Our ref; S/156/24

## PLANNING CONSULTATION RESPONSE

<b>Application No</b>	24/00930/FUL
<b>Proposal</b>	Installation of three air core reactors, switchrooms, with ancillary infrastructure and associated works including new access onto Livesey Street, erection of a security fence, internal drives and cable connection to Neepsend Substation to supply reactive absorption grid stability to the National grid as part of Voltage 2026 initiative
<b>Address</b>	Land At Rear Of Owlerton Sports Stadium Livesey Street Sheffield S6 2BL

Drawing Title:
 PROPOSED SITE PLAN

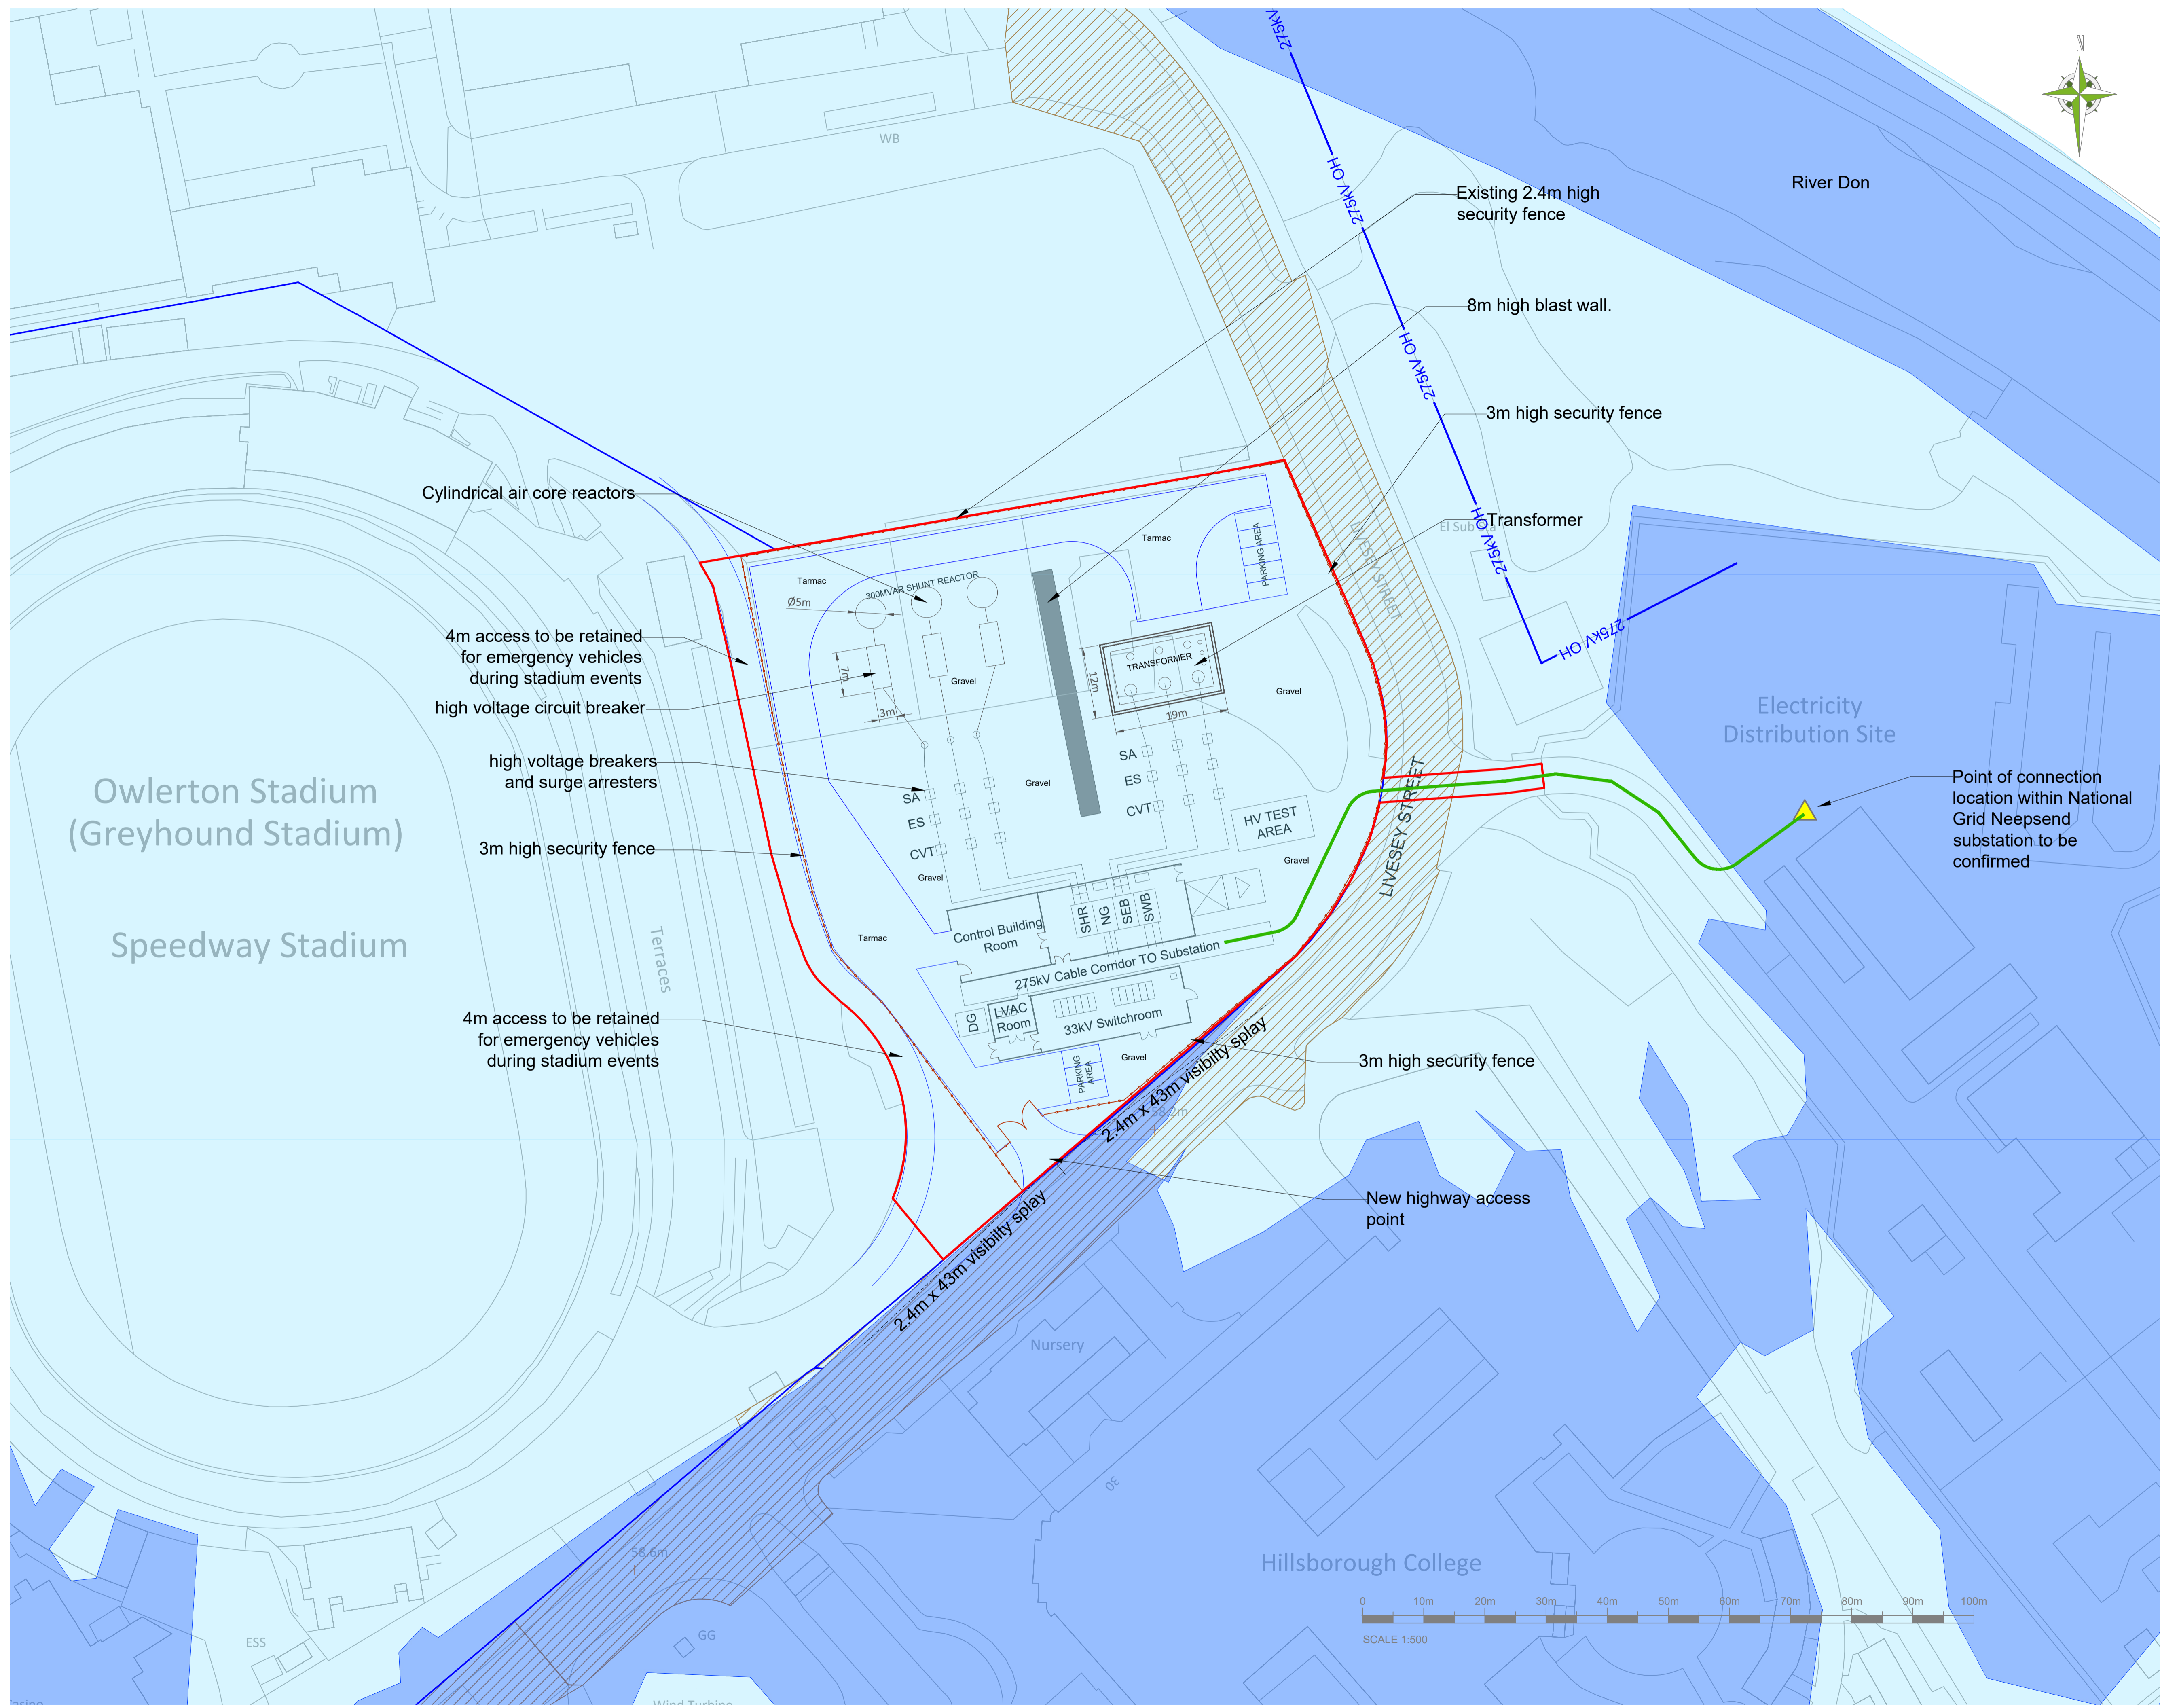
I would recommend that the proposed fencing is a minimum of a 3 metre '358' weld mesh perimeter fence conforming to LPS1175 SR2 as a minimum. The fence should be fixed/concreted into the ground. Access gates should have 'lock shrouds' and be the same hight and standards of the perimeter fence.

Consideration should be given to installation of a fence security topping and the installation of a monitored PID's system in addition to any other internal intruder detection system.

Drawing Title:  
 33kV SWITCHROOM

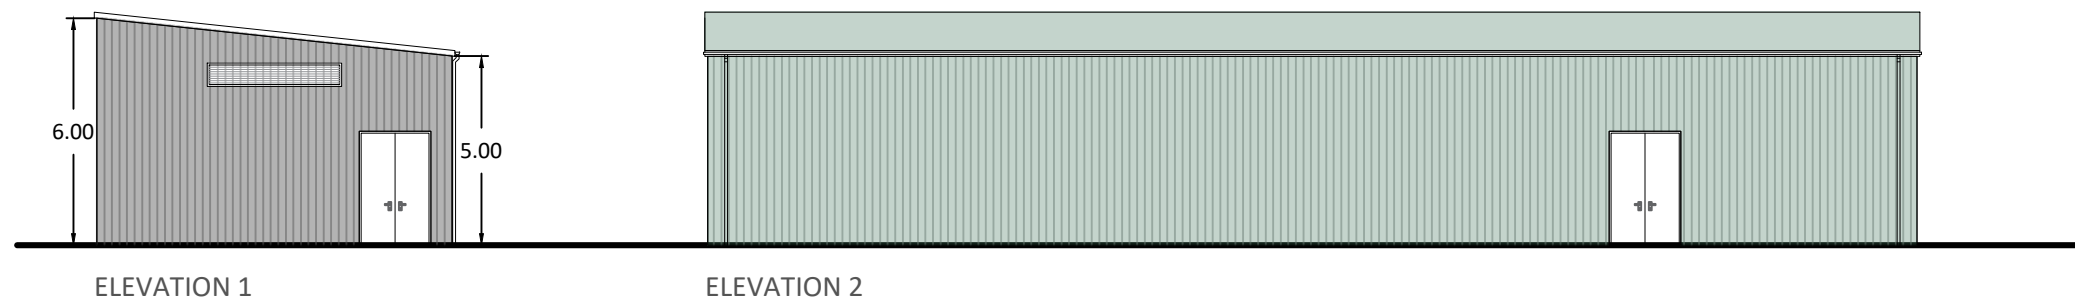
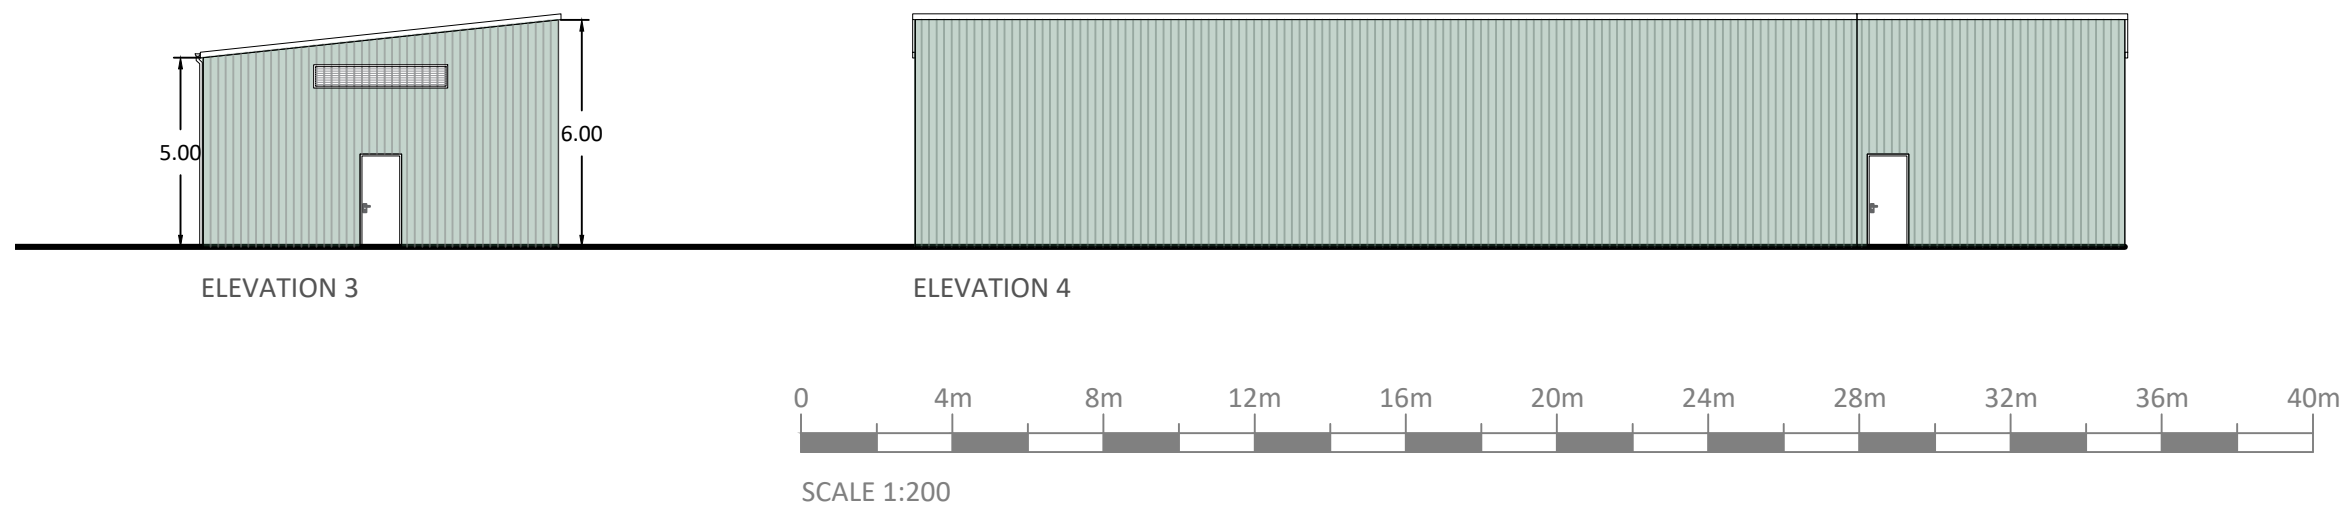
- Roller shutter doors should conform to LPS1175 SR3 as a minimum with a central ground anchored locking mechanism or external anti ram bollard/gate.
- Any windows should have solid hinged shutters that can be closed and secured when staff are not on site.
- Doors that can facilitate lock shrouds should do so.

- All fire doors should void of any external door furniture.
- Any ventilation grills should be robustly constructed and secured into the fabric of the building, alternatively protected with security grills to prevent removal and unlawful entry.
- Any external cabling should be buried or protected by conduit.
- CCTV poles should have 'Anti Climb Spiked Collars' fitted.
- Security lighting and external 'flashing strobe lights' should be fitted and programmed to activate when the PID/intruder alarm system detects an intrusion. This will not only give a visual alert to the offenders but also assist in guiding emergency response services to the site. Lighting should be installed and coordinated with CCTV to provide quality CCTV images.
- Consideration should be given to DNA based property marking, spray systems and signage.
